From: Contact Centre (CRM) <contact@ribblevalley.gov.uk>
Sent: 20 June 2022 20:51
To: Planning
Subject: Planning Application Comments - 3/2022/0465

Planning Application Reference No.: 3/2022/0465

Address of Development: Post office, 1-3 Bridge Road, Chatburn

Dear Sir or Madam,
Please accept my comments on the planning application for The Post Office
1-3 Bridge Road
Chatburn
BB7 4AW

proposed east elevation

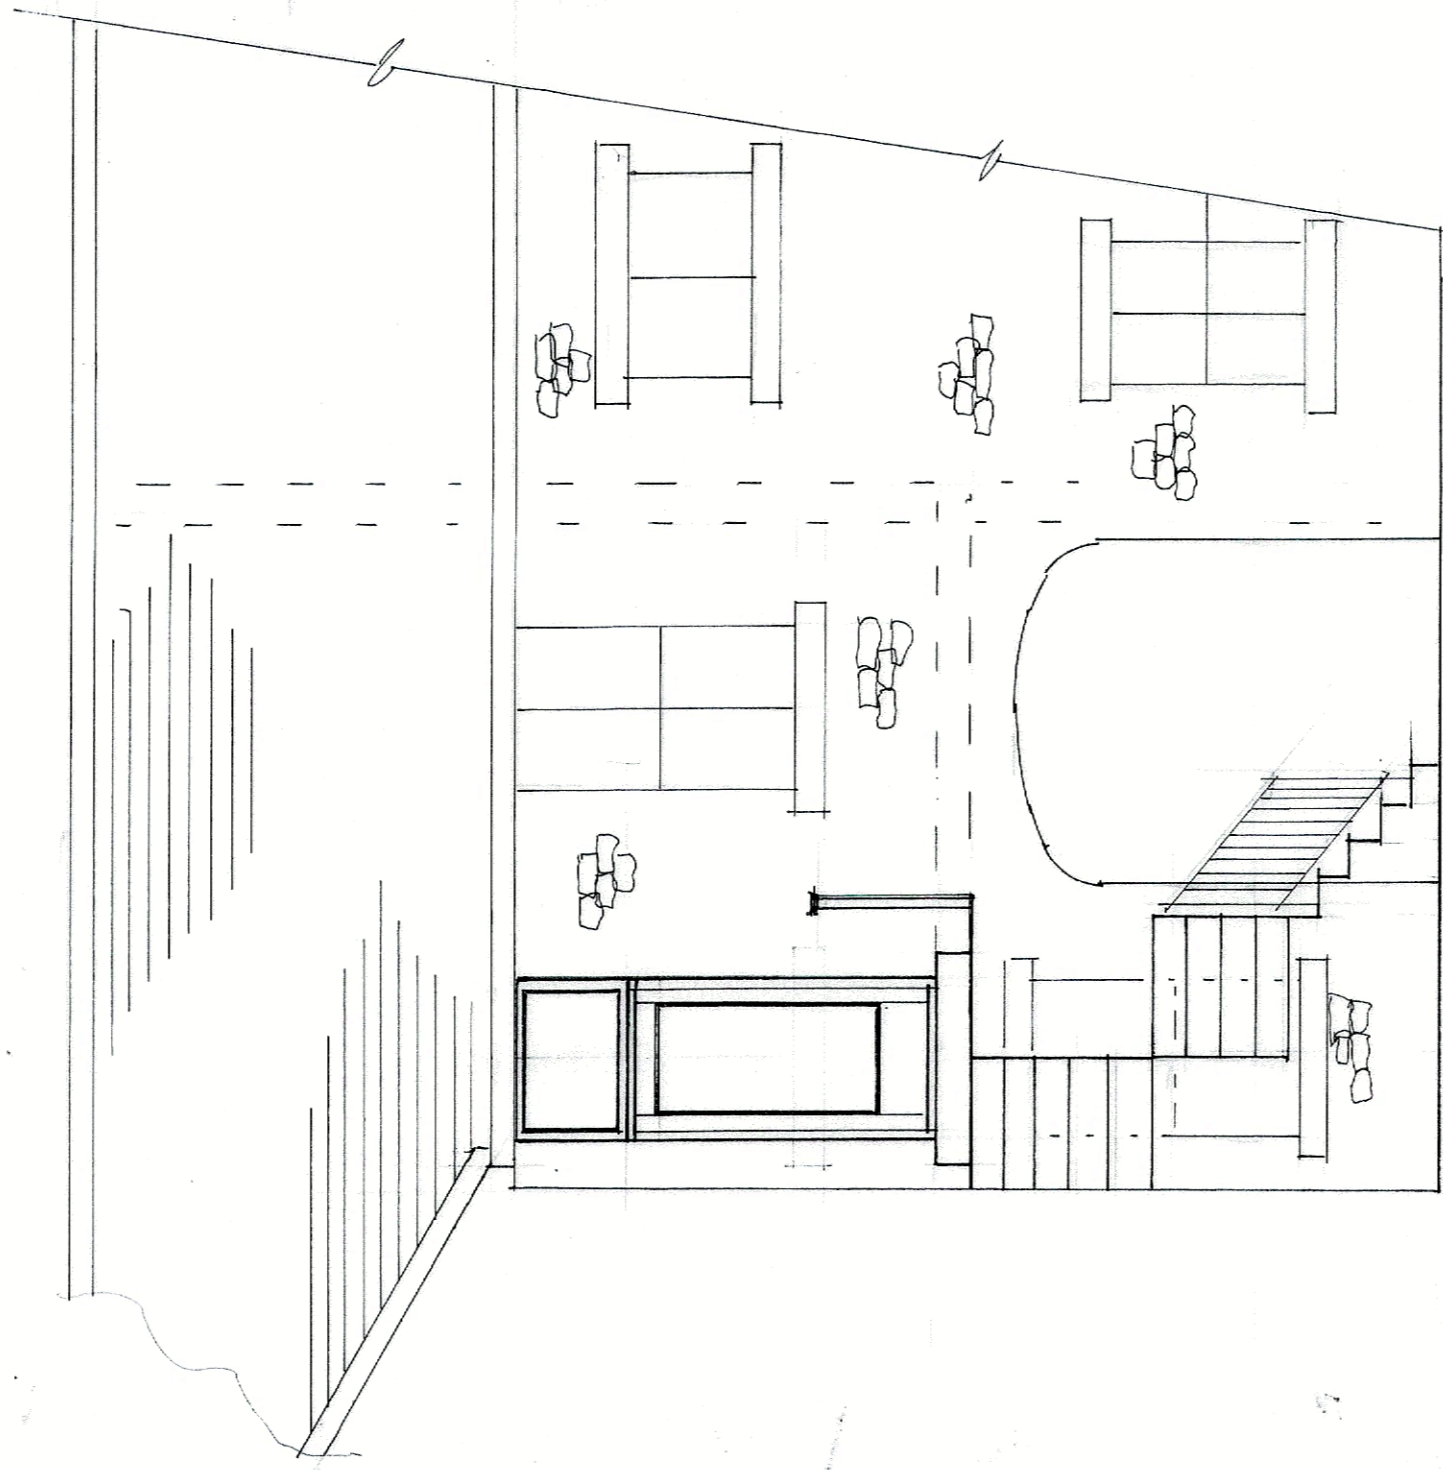
The planning statement does not acknowledge that the property is in a flood risk area, with the rear of the properties on Ribble Lane flagged as a flood risk area on local government searches. This would also be the case for the rear of the Post Office which is suggested a the main entrance for two of the proposed flats. Should a flood occur, the properties on Ribble Lane have an alternative escape route through front doors onto Ribble Lane where as the proposed metal dog legged staircases for two of the bedsit/flats have no such exit point.

The proposed metal stairways on the north and east elevations are not sympathetic to the other properties in this conservation area. The planning statement makes reference to 'high quality design' but dog leg metal staircases are not sympathetic to the character of the buildings in the conservation area and are not high quality design. The noise levels created by footfall up two separate metal stairways will adversely affect the immediate properties and the fact that potential tenants will be at first floor height to enter the suggested flats will impact on the privacy of the rear gardens of the local residents.
